Our Ref: TR010026

Date: 22 July 2019

Application by Highways England for an Order Granting Development Consent for the A30 Chiverton to Carland Cross Scheme

Procedural Decisions, request for further information and change to the timetable

Drawing Title **FIGURE 7.6 - ENVIRONMENTAL MASTERPLANS SHEET 18 OF 20**

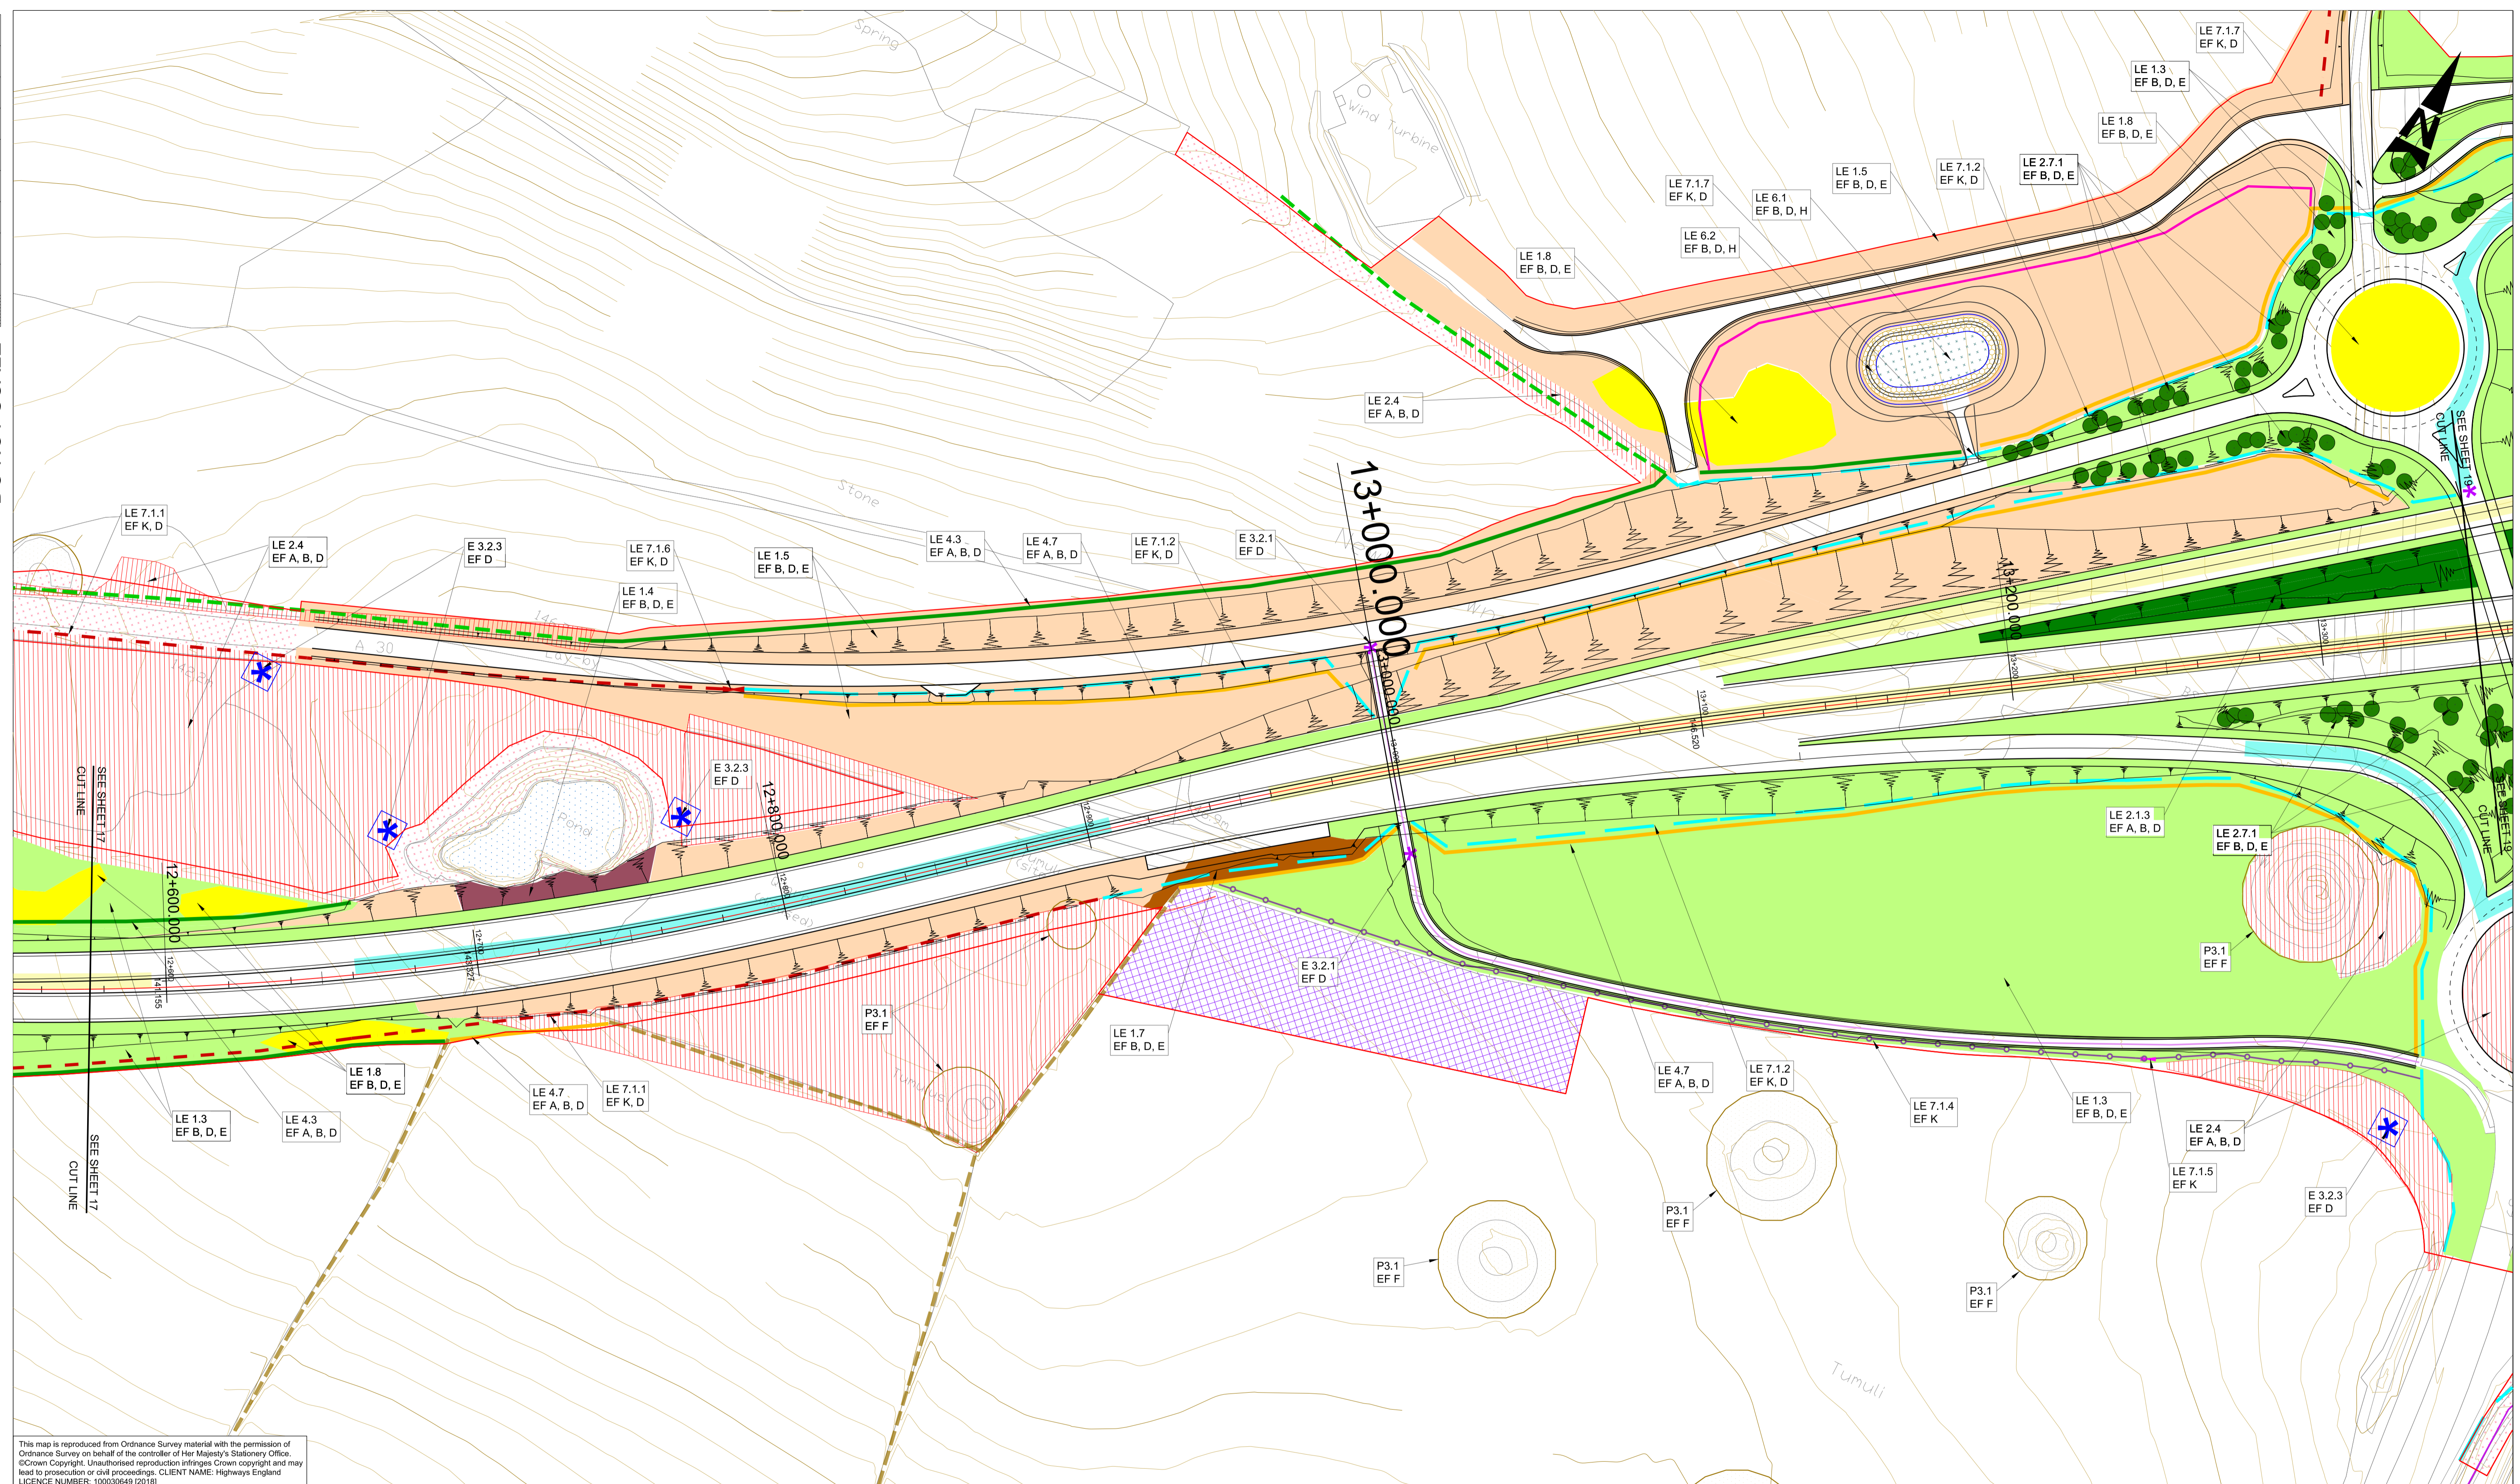
- An elevated viewing area (height of up to 1.2m) to the west of footpath UU as shown on Sheet 18 of Figure 7.6 Environmental Masterplans (Document Reference 7.6(B)).
- A new footpath PR16/WW, of 90m length to connect footpath UU to the southern section of the existing open space land, as shown in Sheet 8 of the Rights of Way and Access Plans (Document Reference 2.5(D)).

The ExA is satisfied that the amendments do not require any new land beyond the Order limits; do not affect any new parties; and, having the consent of all Affected Persons, are not subject to CA. The ExA is satisfied that there is no need for additional publicity and consultation on this matter and that acceptance of the non-material amendment into the Examination process at this stage allows anyone who wishes to make comment to do so.

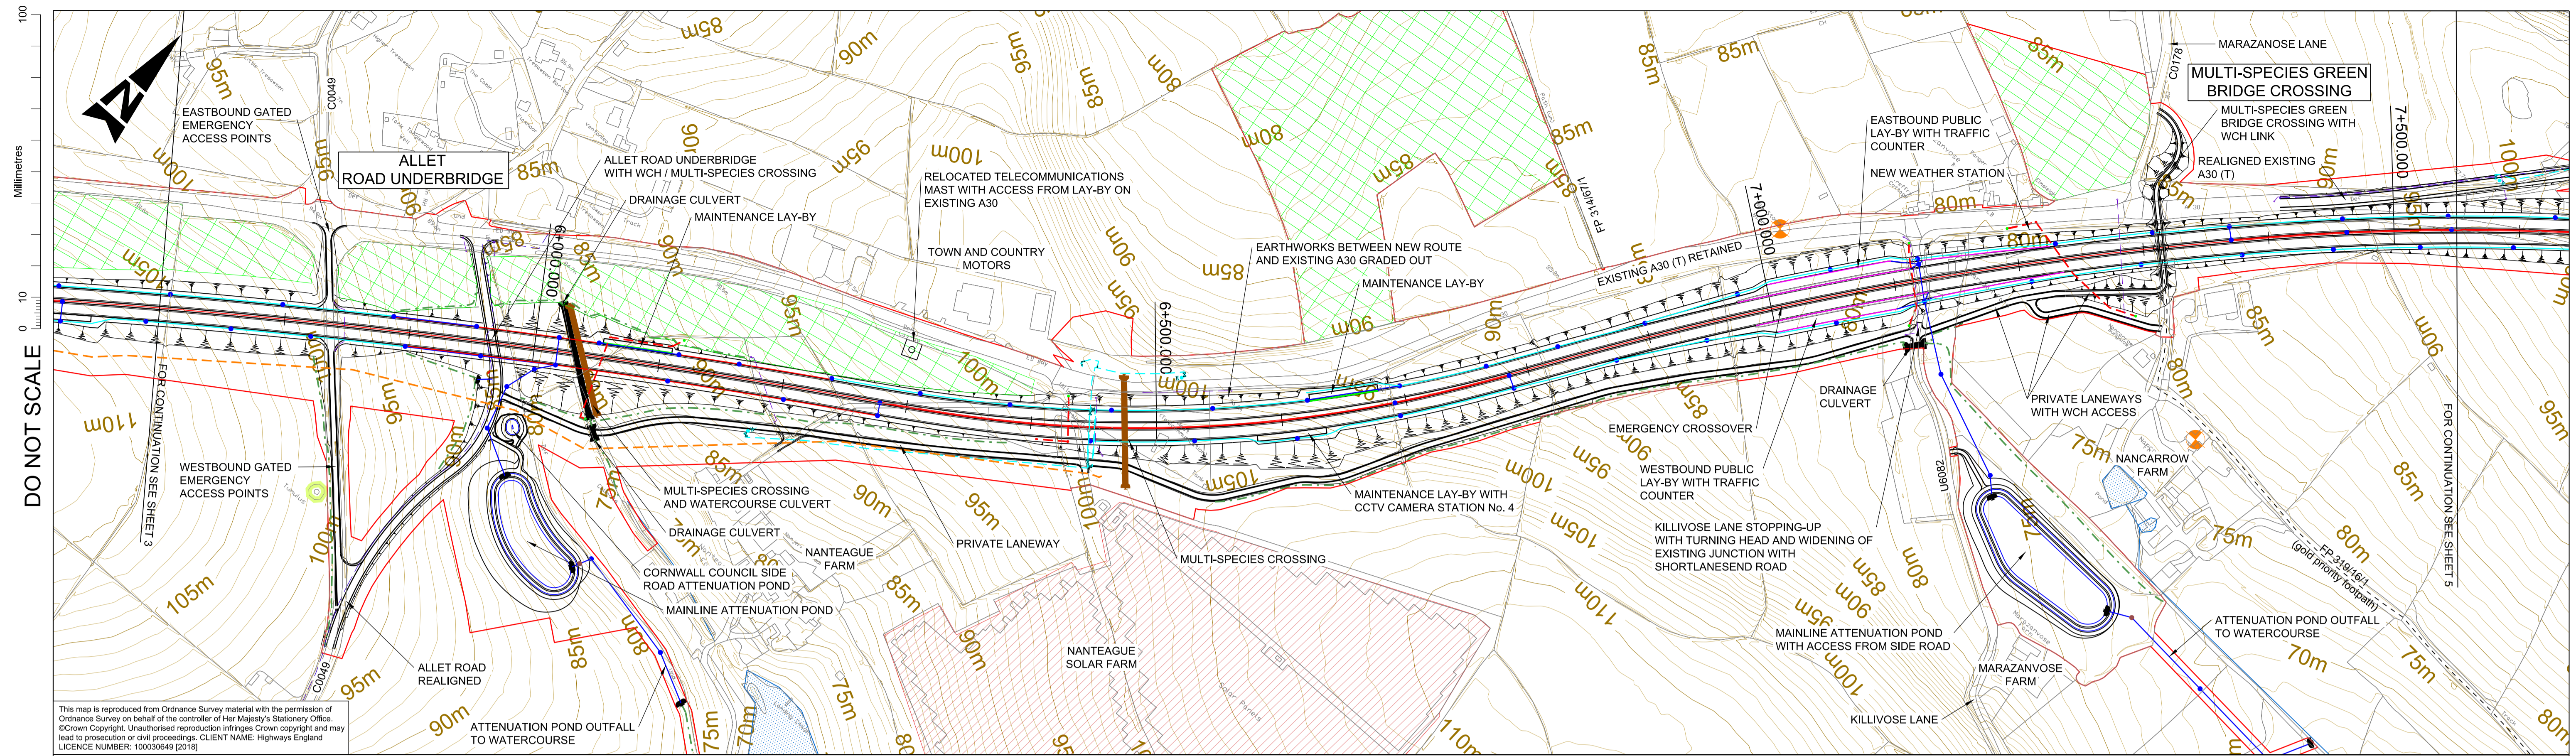
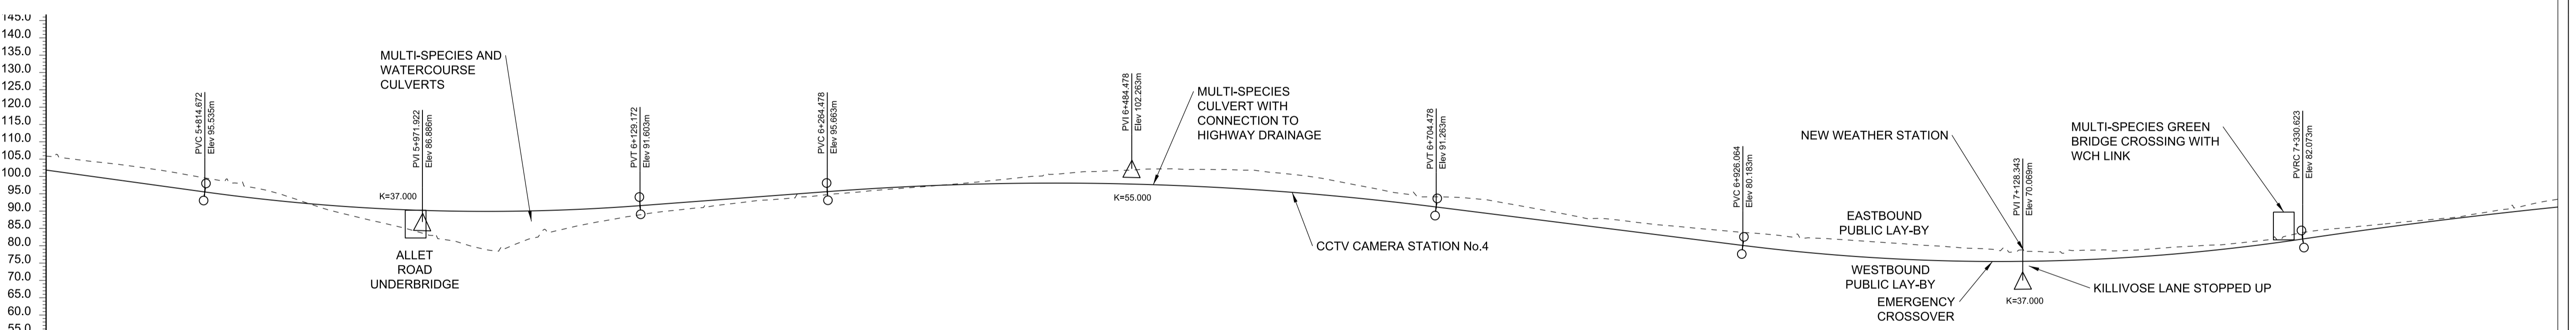
- Removal of the existing mast and the construction of a new mast to the north east of the existing mast, with access from the existing A30, as shown on Sheet 4 of the General Arrangement and Section Plans (Document Reference 2.6(C)).
- The new location would not require any changes to the proposed compulsory acquisition (CA), as previously suggested.

The Examining Authority (ExA) is satisfied that the amendments do not require any new land beyond the Order limits; do not affect any new parties; and, having the

consent of all Affected Persons, are not subject to CA. The ExA is satisfied that there is no need for additional publicity and consultation on this matter and that acceptance of the non-material amendment into the Examination process at this stage allows anyone who wishes to make comment to do so.
